# **Lime Down**

Solar Park

## **Statement of Common Ground with Natural England (Clean)**

**Document Reference: EXAM/8.4**

Title:
Figure 4-4: Main Infrastructure Layout Changes between PEIR and DCO Application

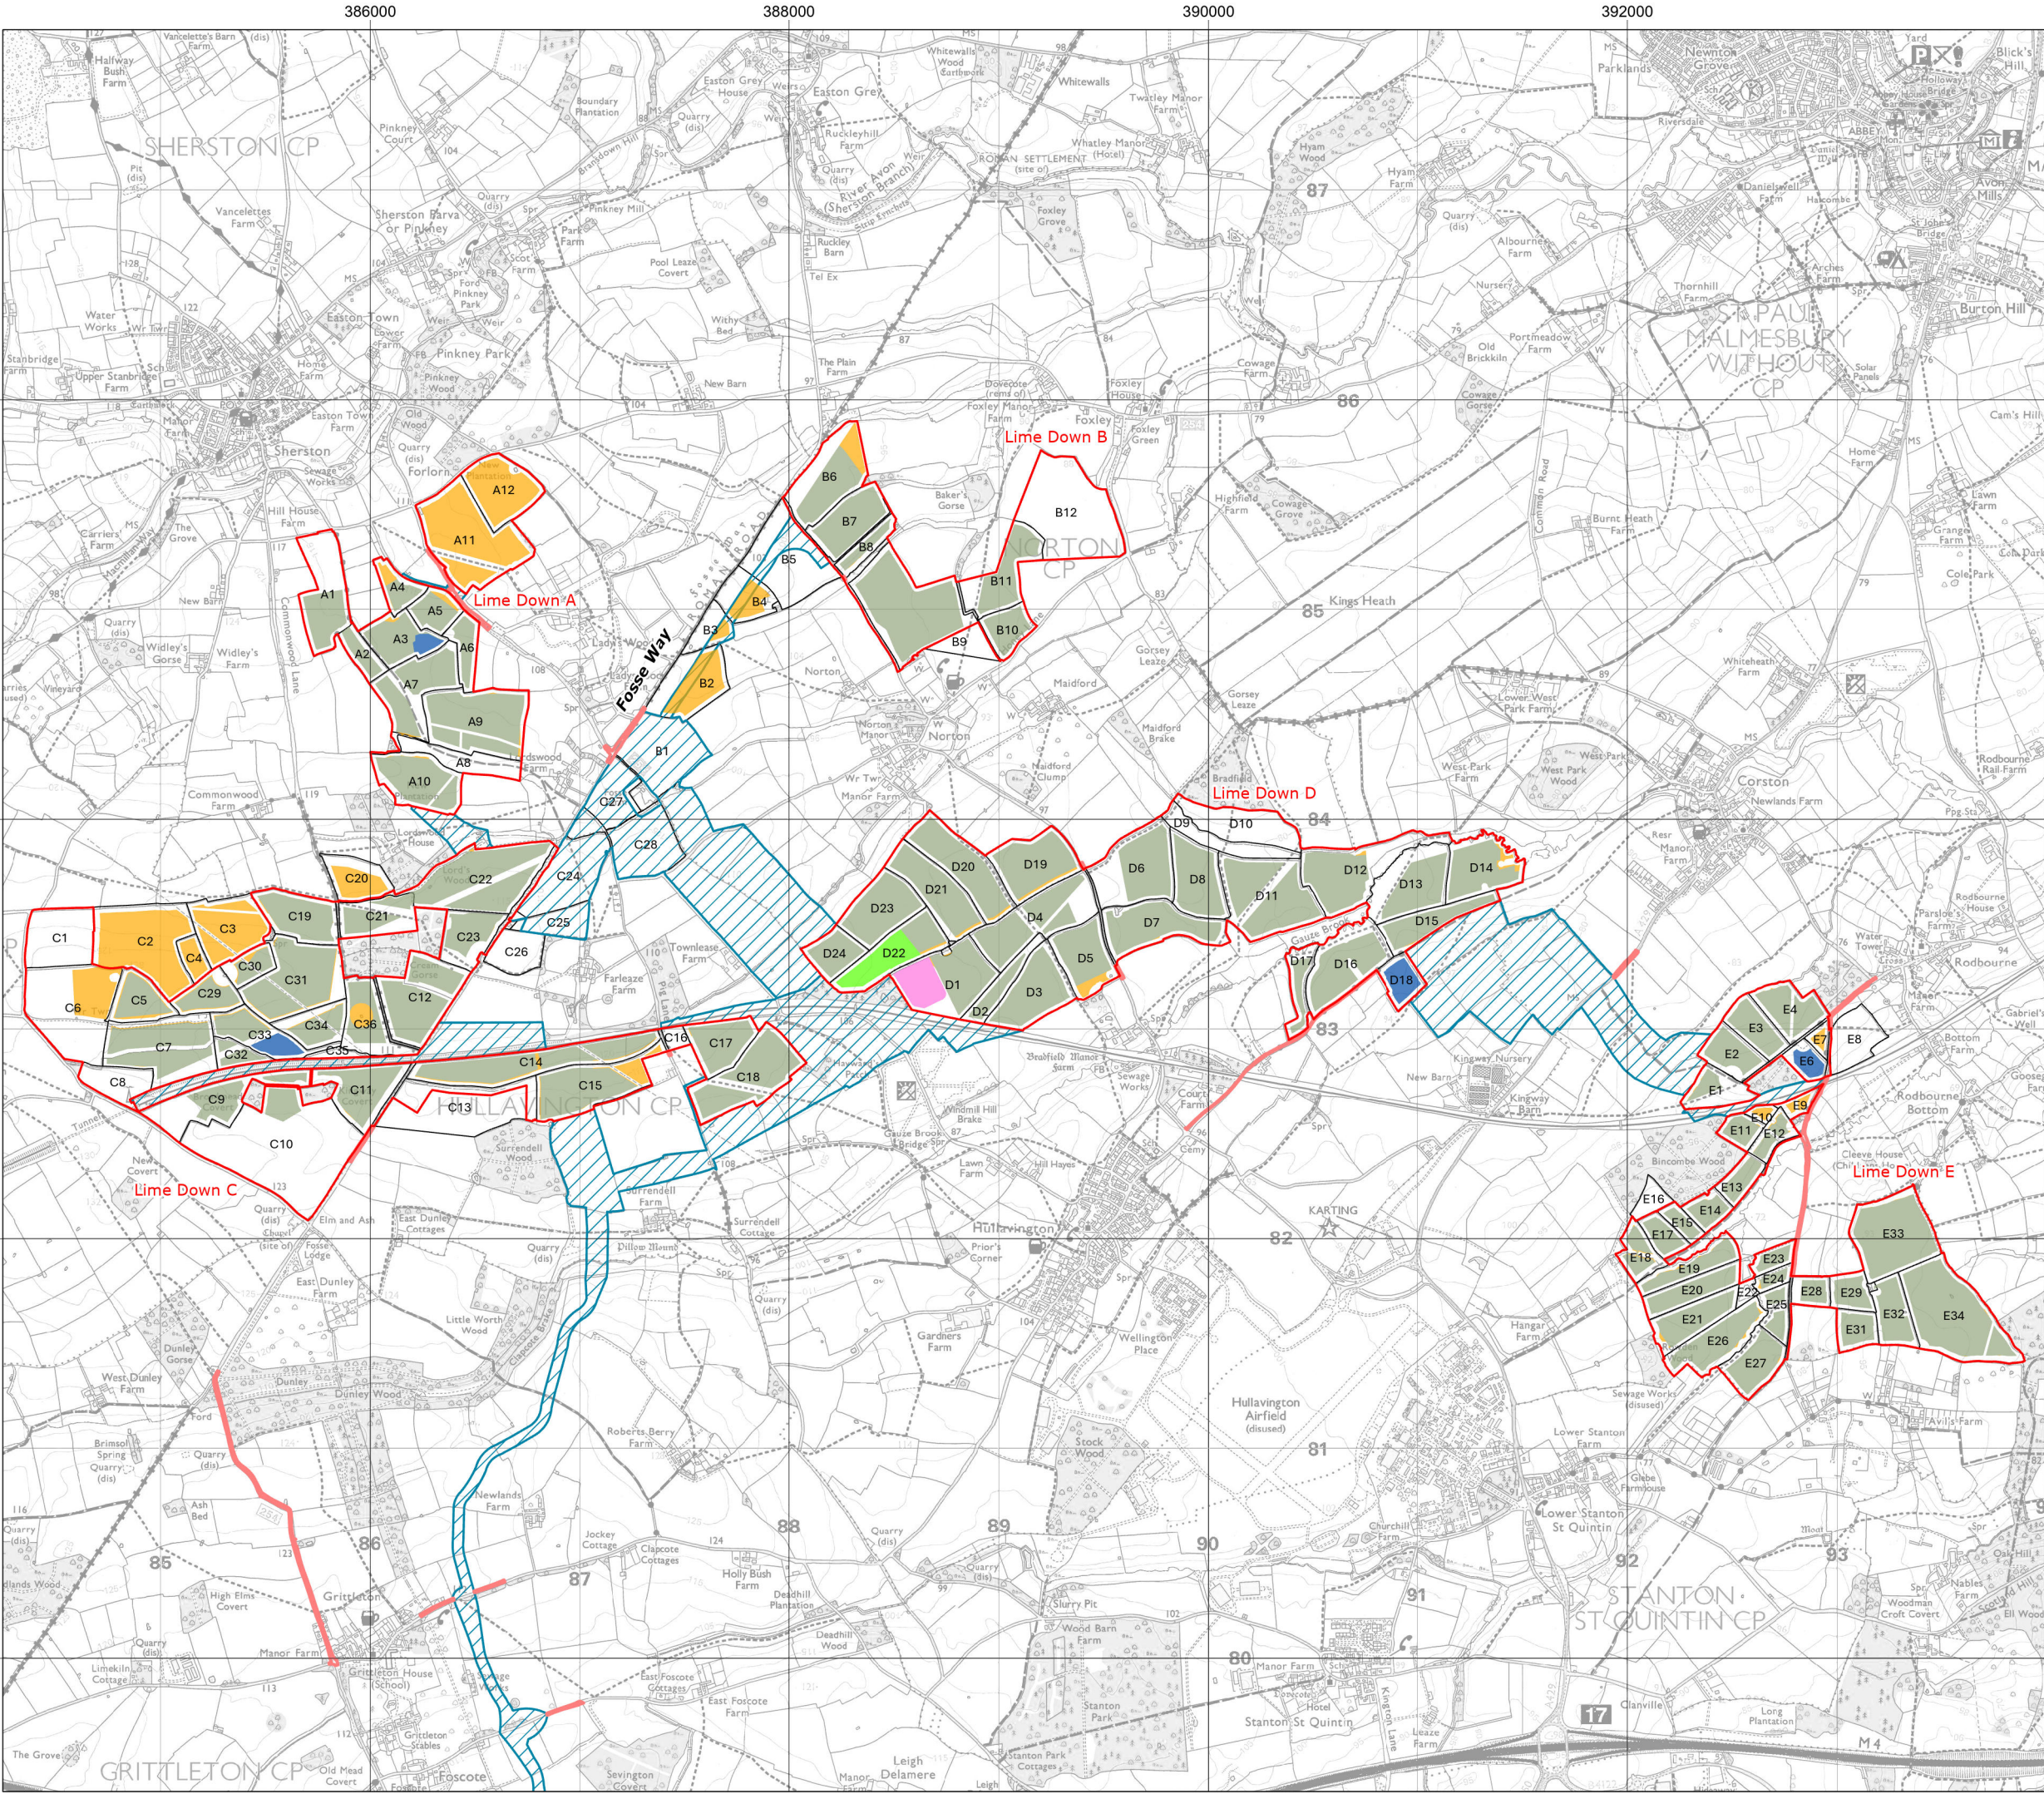
Reference	Sub-topic	NE Position	Applicants Position	Status
3.1.1	Extent of panels within Lime Down C	Recommended that the extent of panels within Lime Down C is reviewed to avoid adverse landscape and visual effects on the CNL. Where panel areas are reduced, this should be used to provide landscape and ecological enhancements, particularly for lesser horseshoe bats.	As shown on the Works Plan, panels will not be located in the parts of fields directly adjacent to the National Landscape boundary within fields C1, C6, C8, and C10 retained clear of panels. Photomontages from 13 viewpoints demonstrates that this limits the landscape and visual impact of the proposed development.	<b>Under Discussion</b>
